Office of Environment & Heritage

Your reference SSI-5414
Our reference: Doc12/45371
Contact Susan Harrison 9995 6864

I refer to your letter received by the Office of Environment and Heritage (OEH) on 30th October 2012 inviting a submission on the exhibited Environmental Impact Statement (EIS) for the North West Rail Link, Stage 2 – Stations, Rail Infrastructure and Systems (SSI-5414), including advice on recommended conditions of approval. OEH previously provided comments on the adequacy of the draft EIS for the North West Rail Link Stage 2 on 10 October 2012 (Doc12/40686).

OEH has reviewed the EIS and has the following comments to make on Aboriginal cultural heritage, and flooding.

North West Rail Link EIS  
Relative Flood Level Impacts (PMF)  
Caddies Creek  
Source: AECOM

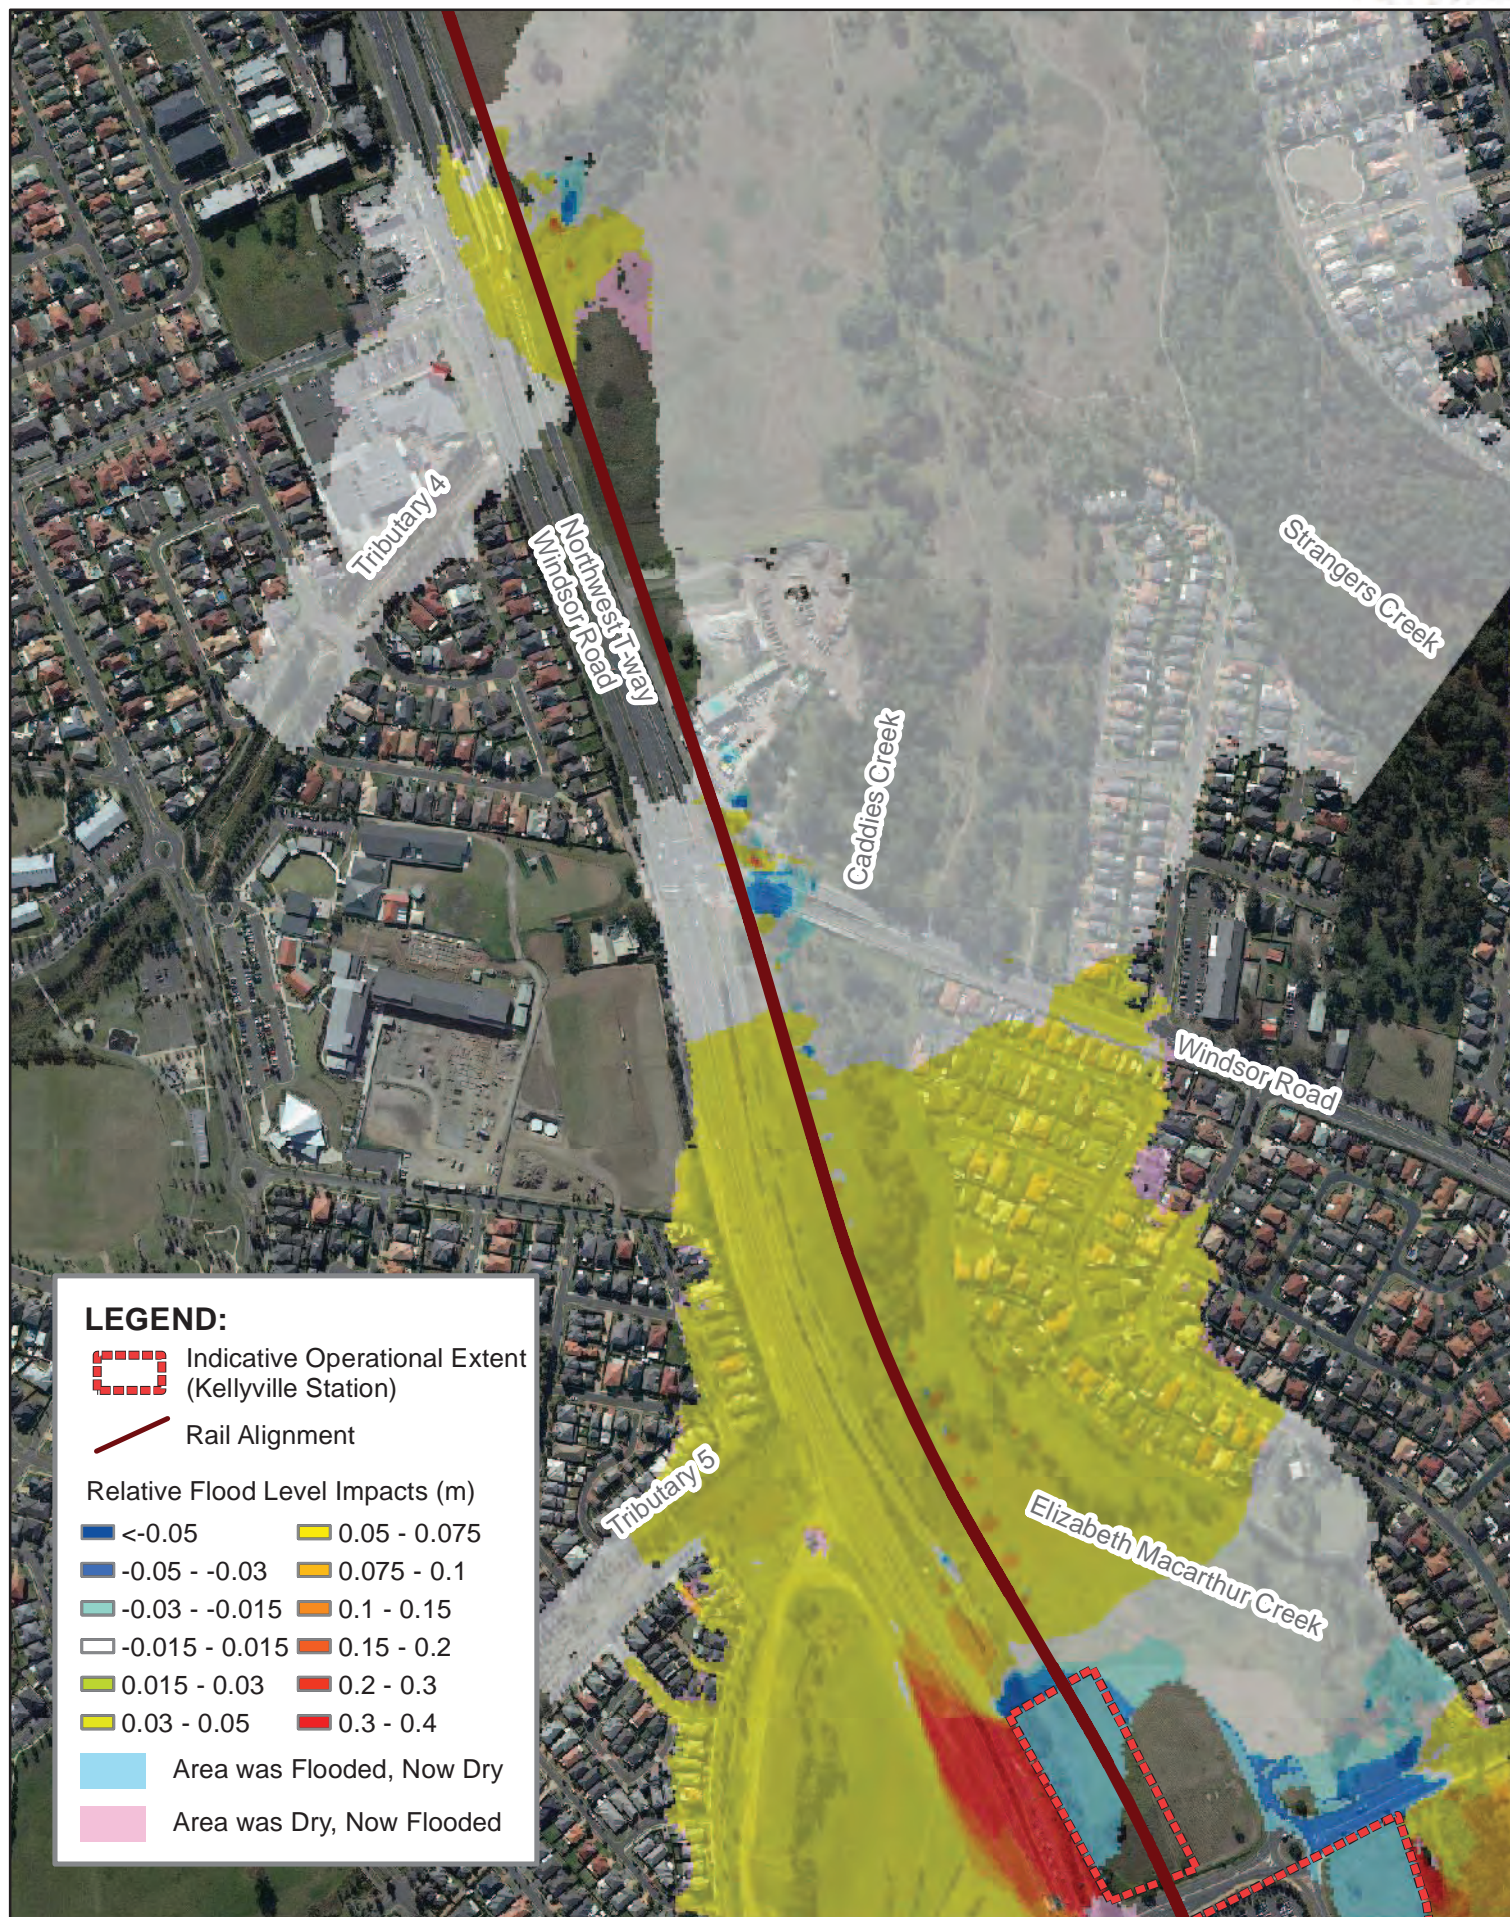
- An increase in flood level up to 0.5 m in PMF flood events in Old Windsor Road and the Transit-way near the intersection with Samantha Riley Drive is indicated (pp.37-38). Although the overall flood extent would not increase significantly in the PMF, it should be noted that vehicle stability would be of concern in the above two locations during such larger floods. Such points of interest should be identified within an emergency response plan in consultation with the State Emergency Services.
